**KIRKLEES METROPOLITAN COUNCIL
INVESTMENT & REGENERATION SERVICE**

Reference No:	2025/62/91807/E
Site Address:	28, The Knowle, Shepley, Huddersfield, HD8 8EA
Description:	Erection of two storey rear extension and first floor extension over existing garage
Recommending Officer:	Jennifer Booth

DECISION – REFUSED

OFFICER REPORT

DRAWING TITLE  
GA DRAWING - PROPOSED

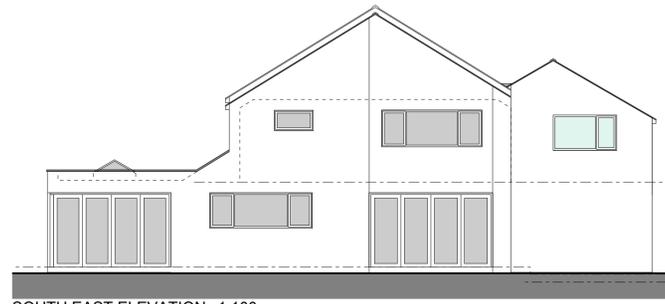
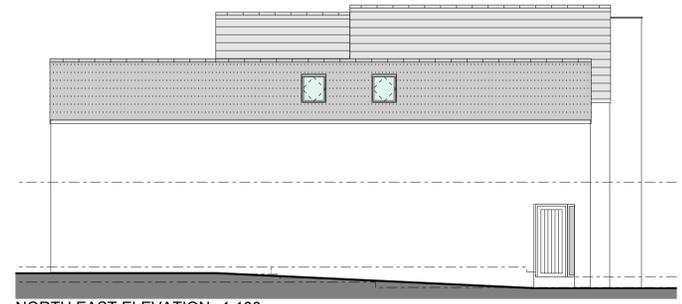
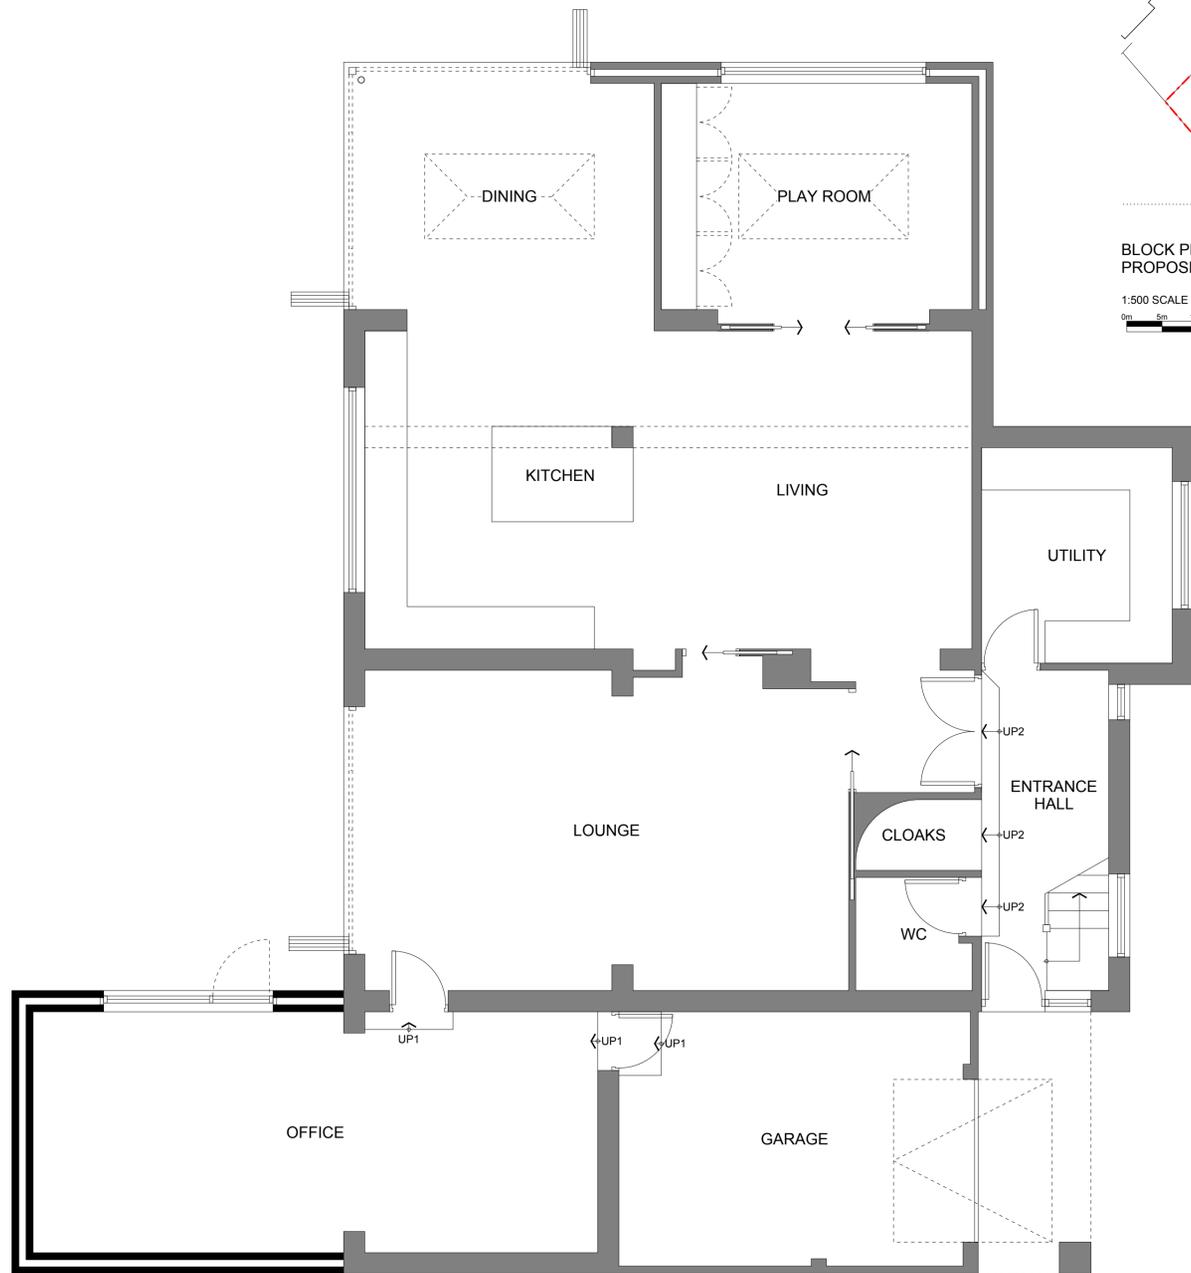
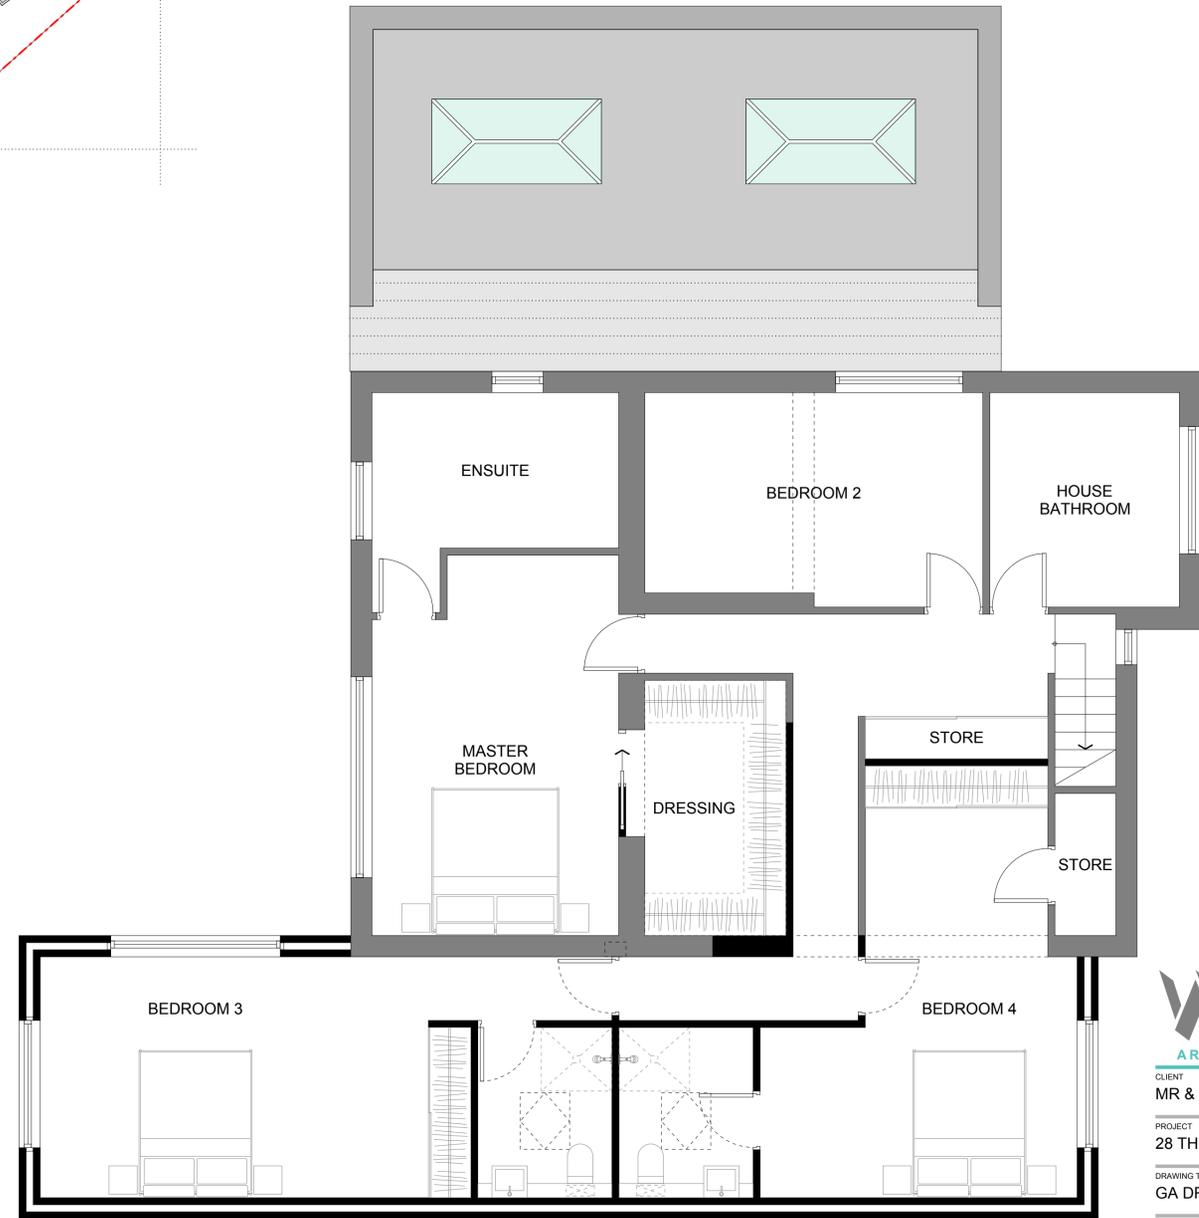
There have been a number of extensions to the original dwelling. The original dwelling as set out within drawing 057-01 submitted as part of application 2015/93509 details that the footprint of the dwelling is 159m². The scheme as proposed is detailed within drawing 03RevC submitted as part of this application and demonstrates the proposal, in cumulation with the original dwelling and subsequent additions which have been completed would have a total footprint of 355m². As such the proposal would, in combination with previous additions, see a footprint / floor space increase which is approximately doubled the size of the dwelling.

In this case it is considered that the extent of the development proposal, when considered in cumulation with other extensions to the property previously consented and undertaken would see the a development which is of a disproportionate size and scale in relation to the original building.

No very special circumstances have been demonstrated or are considered to exist more generally. Therefore it is concluded that by virtue its size, scale and design when taken in cumulation with previous additions the proposed development represents a disproportionate addition over and above the size of the original building and therefore constitutes inappropriate development within the Green Belt for which no very special circumstances have been demonstrated contrary to policy LP57 of the Kirklees Local Plan and policies within Chapter 13 of the National Planning Policy Framework.

The proposed first floor side extension and the two-storey rear element, when assessed in conjunction with the existing roof structure and previous alterations, would result in a development that appears visually incongruous. The roof design, in particular, fails to integrate cohesively with the original dwelling and the previously extended roof forms, leading to a fragmented and unbalanced appearance. The cumulative impact of these additions detracts from the overall architectural integrity of the property and is considered to cause harm to the visual amenity of the area.

The proposed first floor side extension and two-storey rear element, by virtue of their roof design and cumulative impact when considered alongside the original and previously extended roof forms, would result in a development that appears visually incongruous and poorly integrated with the host dwelling. The proposal would detract from the architectural character of the property and the surrounding area, causing harm to visual amenity.

1. By virtue its size, scale, design and when taken in cumulation with previous additions, the proposed development represents a disproportionate addition over and above the size of the original building and therefore constitutes inappropriate development within the Green Belt for which no very special circumstances have been demonstrated contrary to policy LP57 of the Kirklees Local Plan and policies within Chapter 13 of the National Planning Policy Framework.

2. The proposed first floor side extension and two-storey rear element, by virtue of their roof design and cumulative impact when considered alongside the original and previously extended roof forms, would result in a development that appears visually incongruous and poorly integrated with the host dwelling. The proposal would detract from the architectural character of the property and the surrounding area, causing harm to visual amenity. To permit the proposals would be contrary to Policy LP24 of the Kirklees Local Plan, KDP1 & KDP2 of the House Extension & Alterations SPD together with Chapter 12 of the National Planning Policy Framework.
